Ribble Valley Borough Council
Housing & Development Control

Application no: **3/2022/1129**

Address: **Bridge Hey Wood Caravan Park Dunkirk Farm Read BB12 7RR**

Proposal: **Retrospective change of use with minor engineering works and associated landscaping works for the reuse of the former railway embankment and track bed to form an informal recreational amenity area in association with the adjacent holiday park.**

Earth bund and bench seating
Scale 1:200

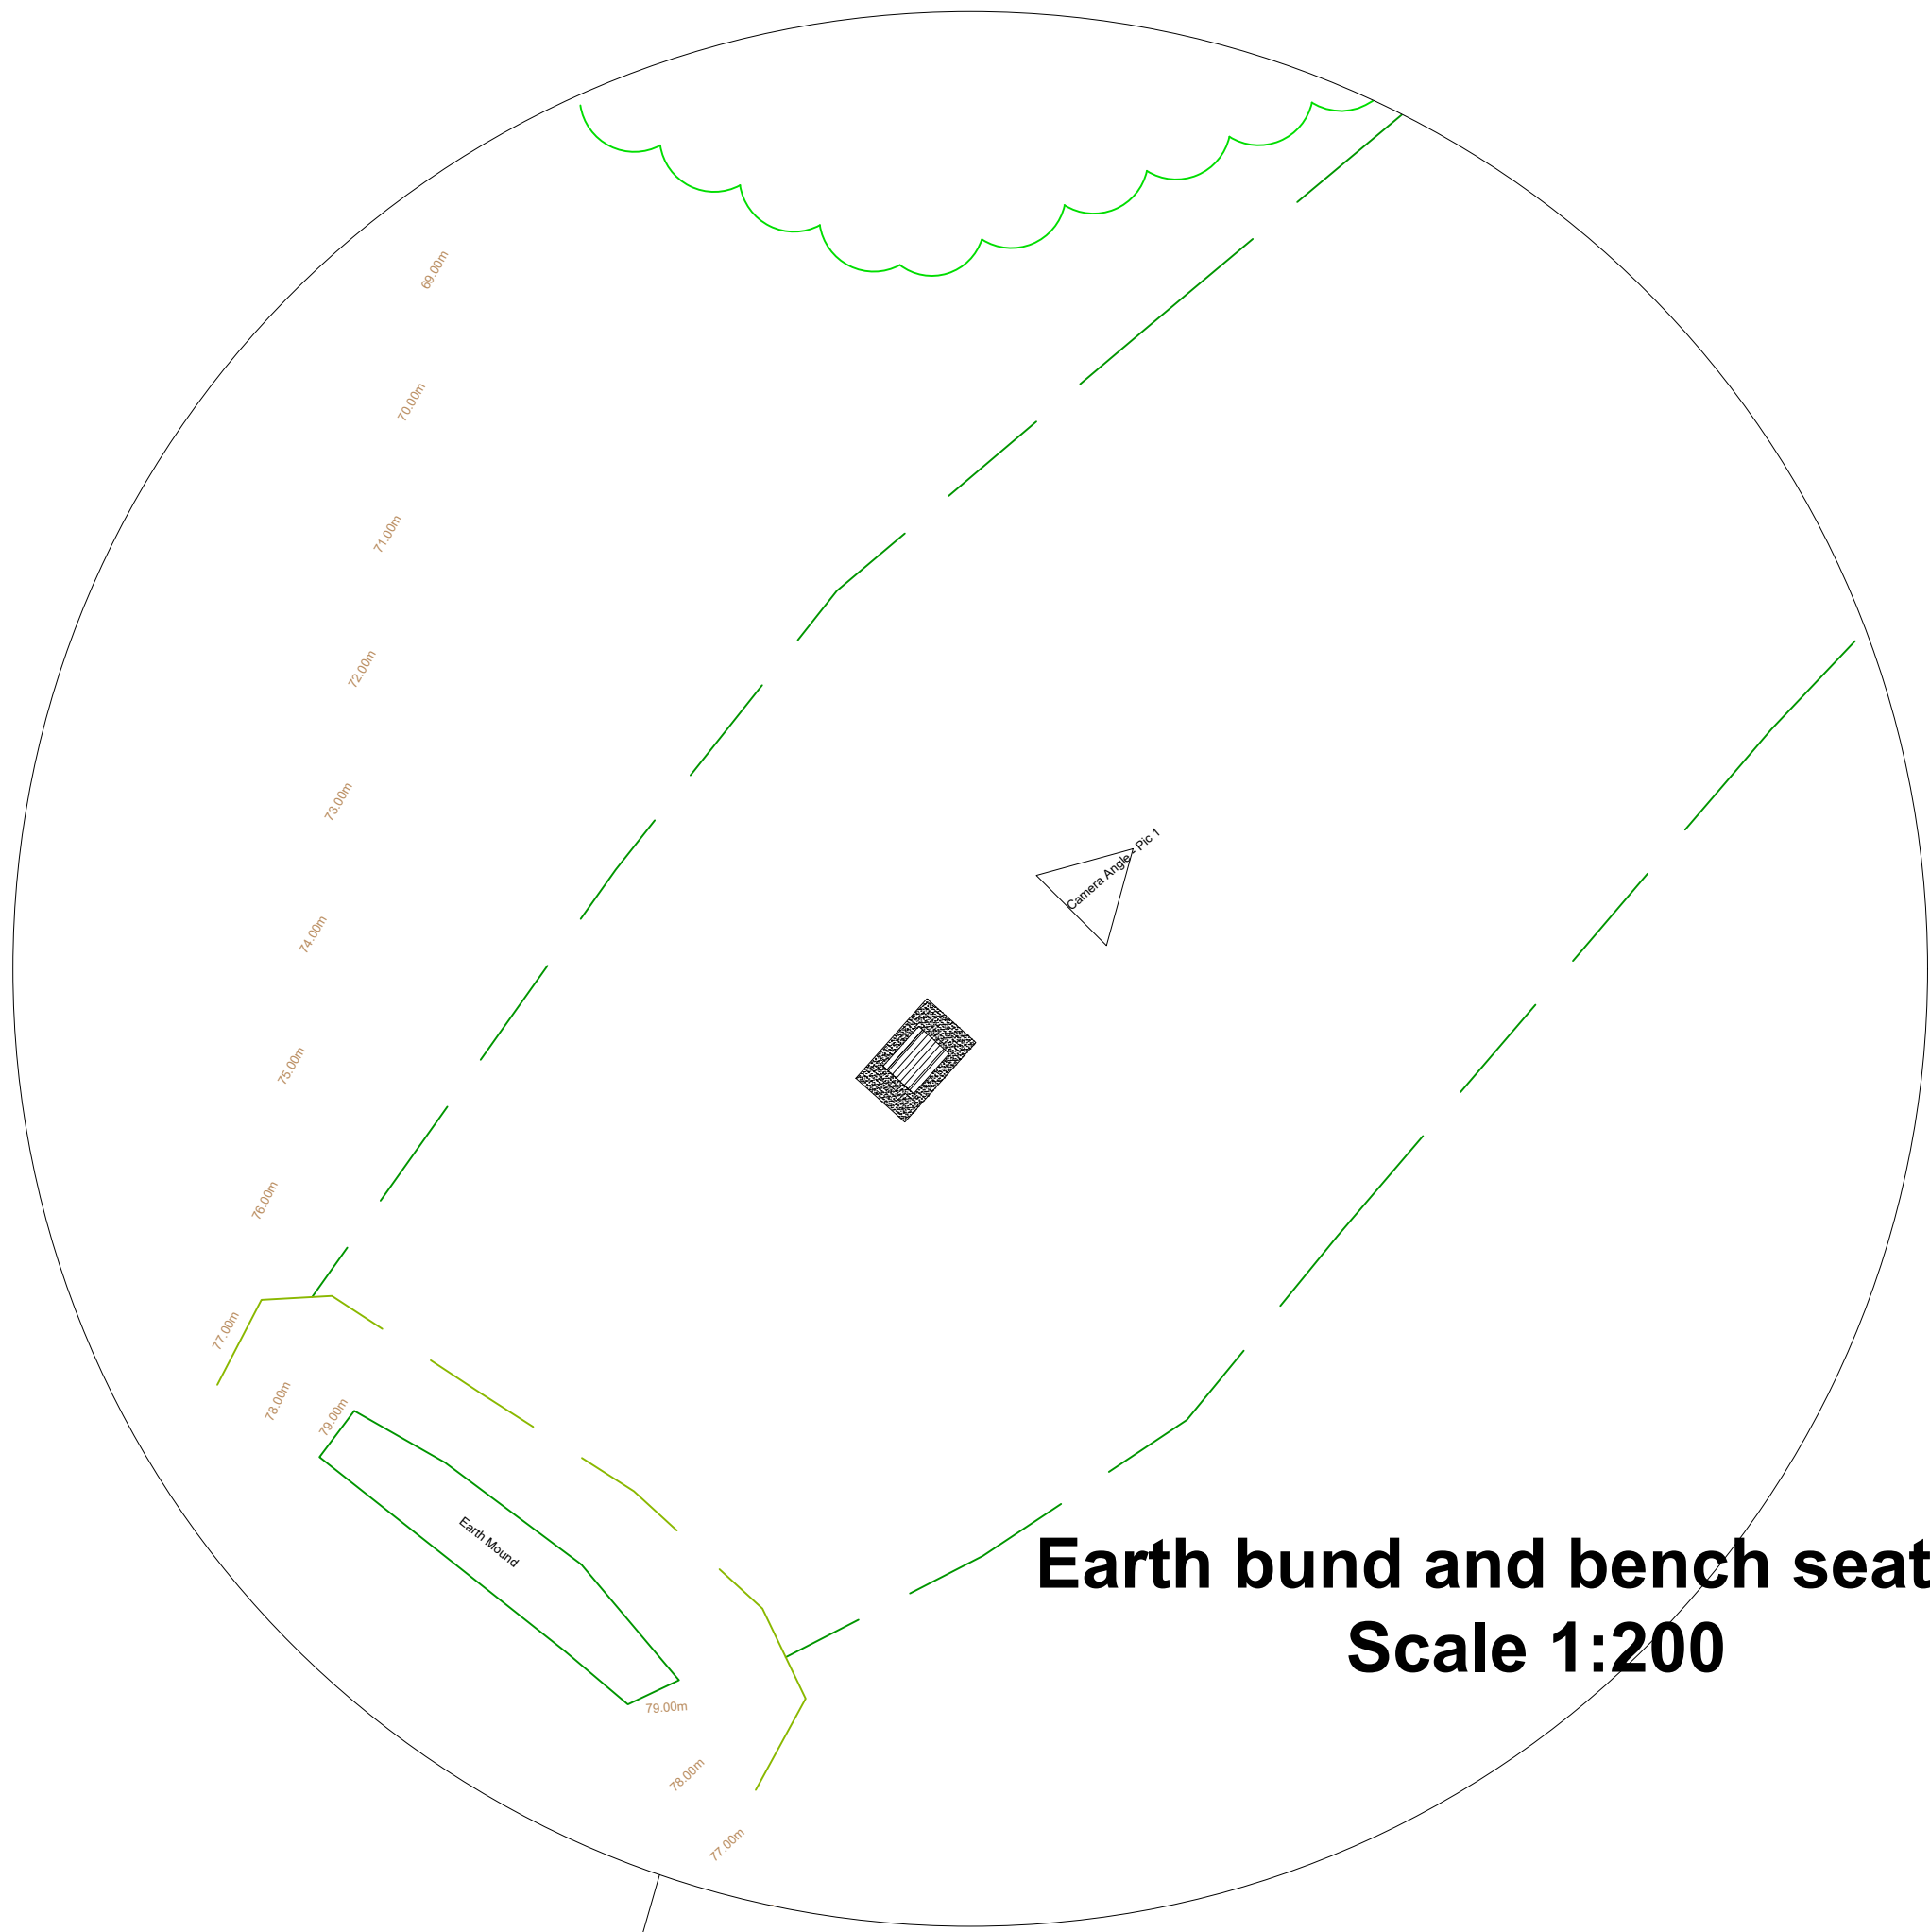
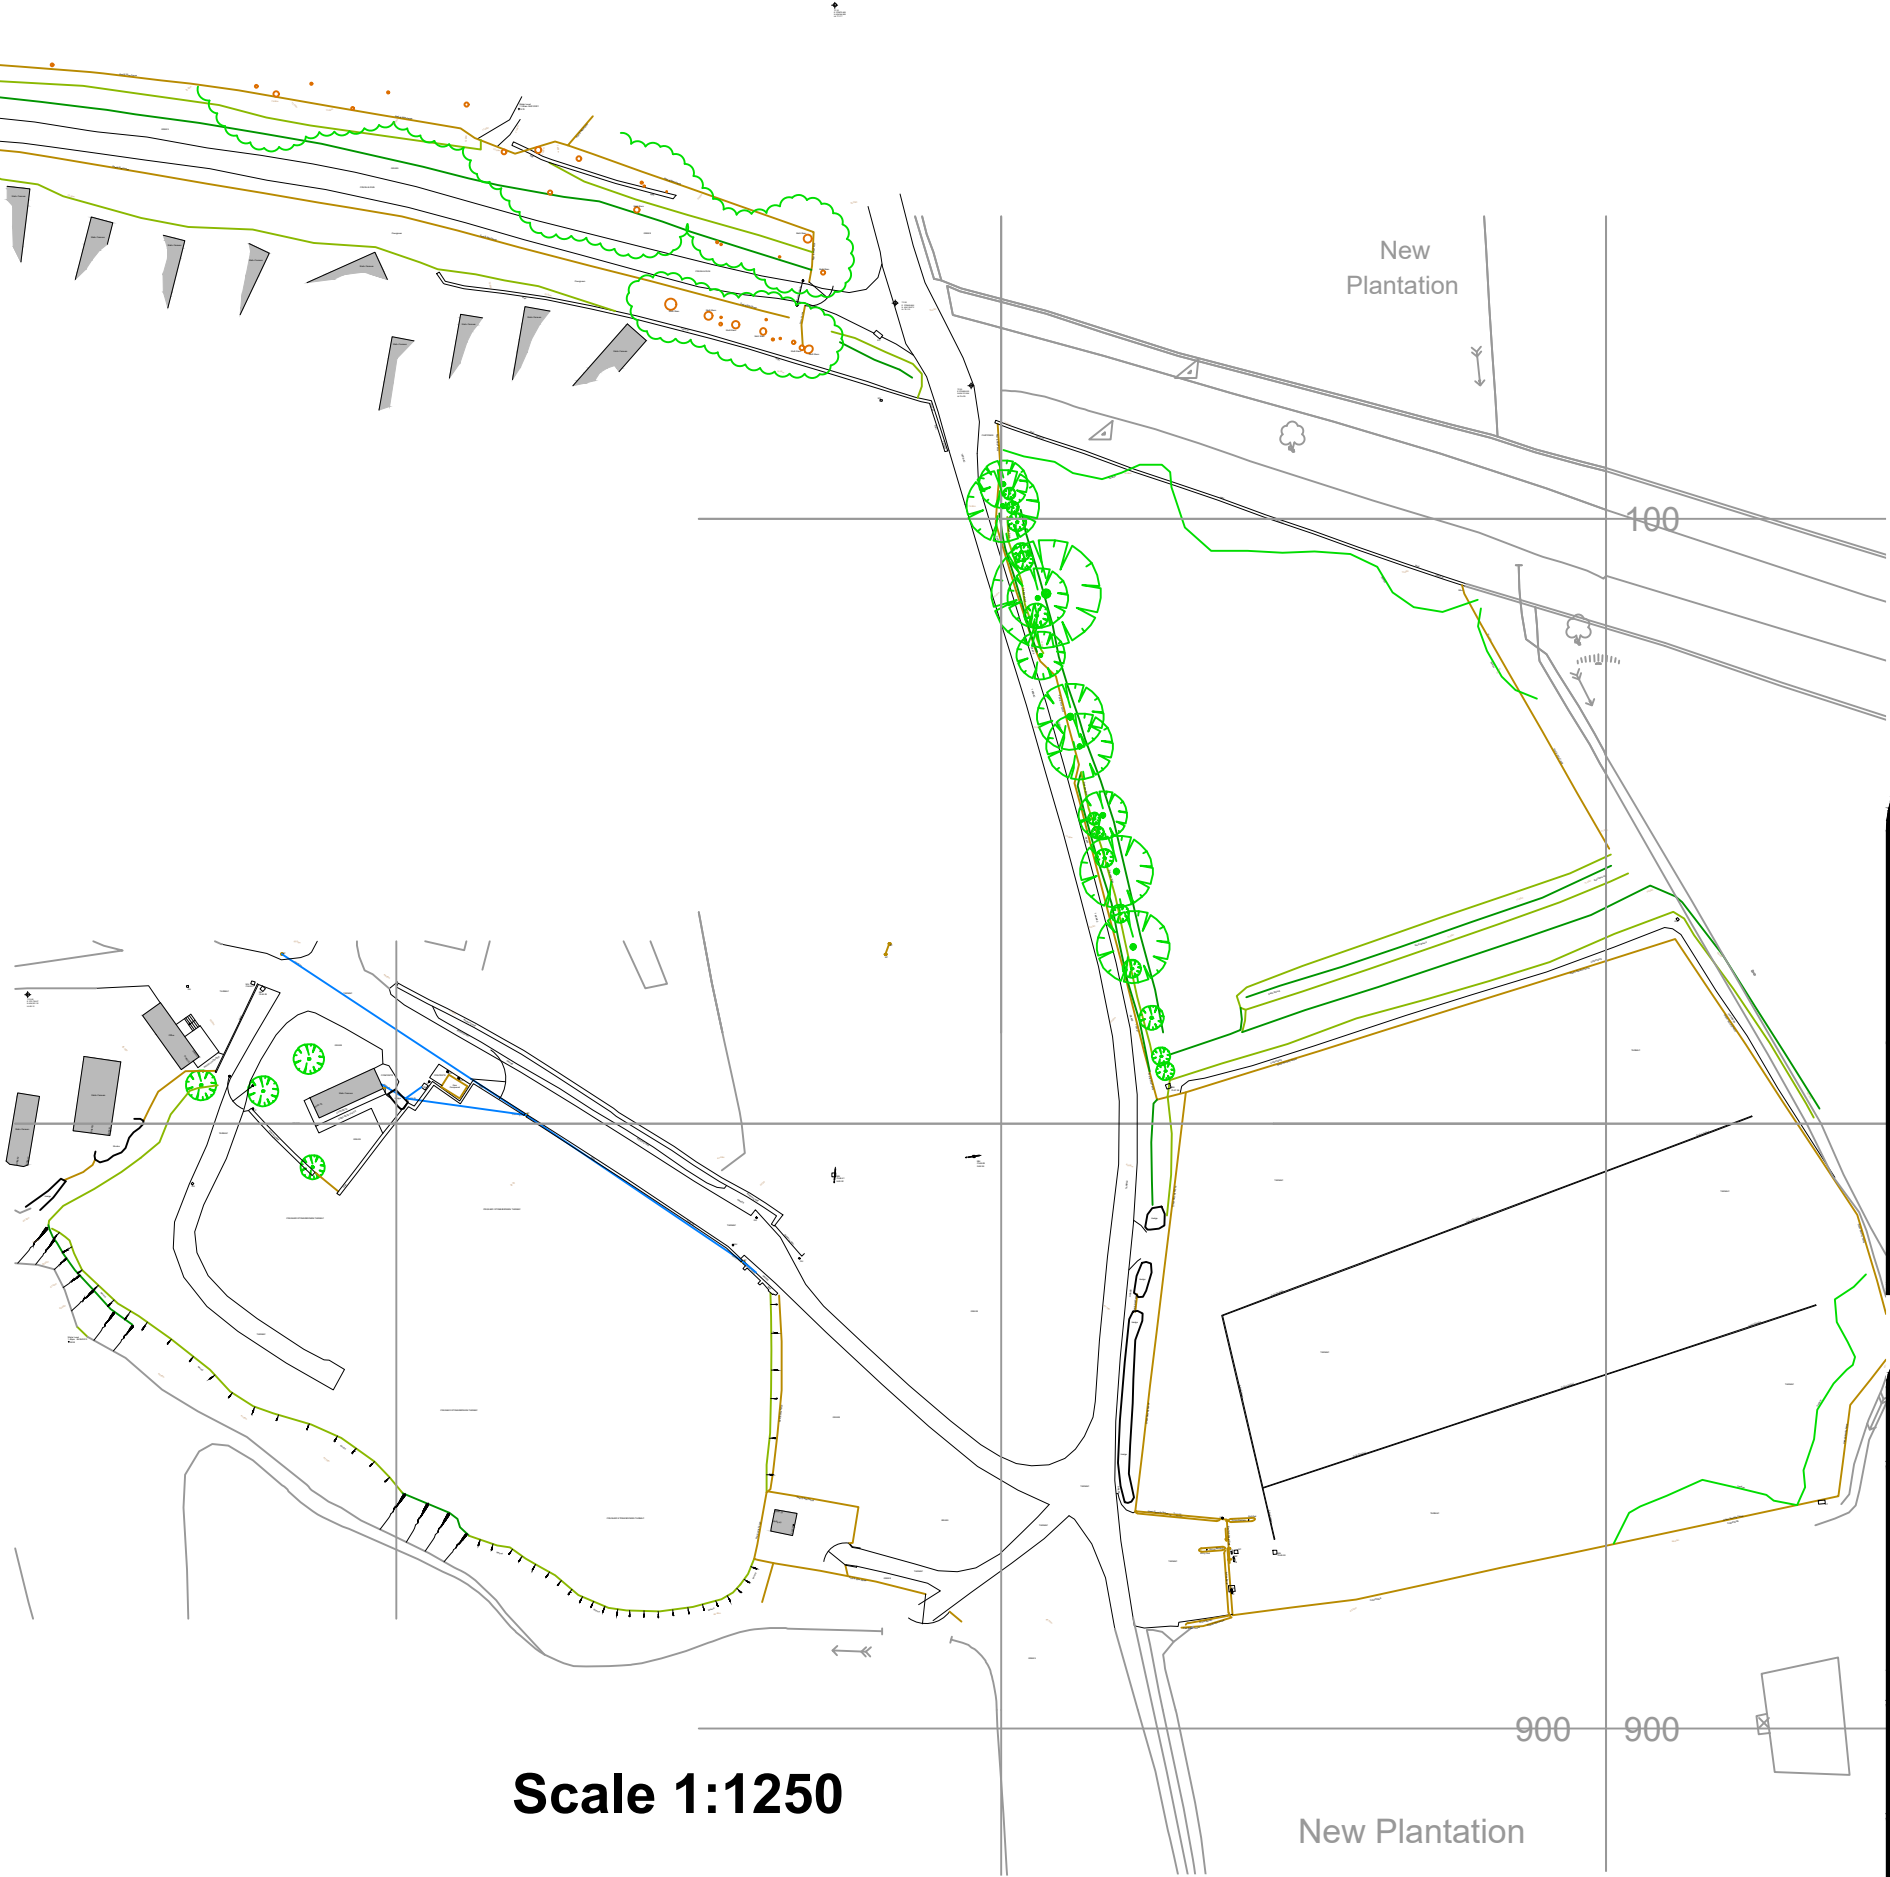
Furthermore, as part of the proposal, works are going to be undertaken adjacent to the viaduct with as described in the Cover Letter, as shown on the Local Planning Authorities planning portal, "the works undertaken involve the excavation of a channel and mound adjacent to the viaduct."

The LHA require further information regarding what type of works are going to be undertaken adjacent to the viaduct, with the LHA needing to ensure that any works will not destabilise the viaduct and impact upon Lancashire County Councils land.

As the works have been completed already, photographs and a description of the works undertaken adjacent to the viaduct will suffice in this case.
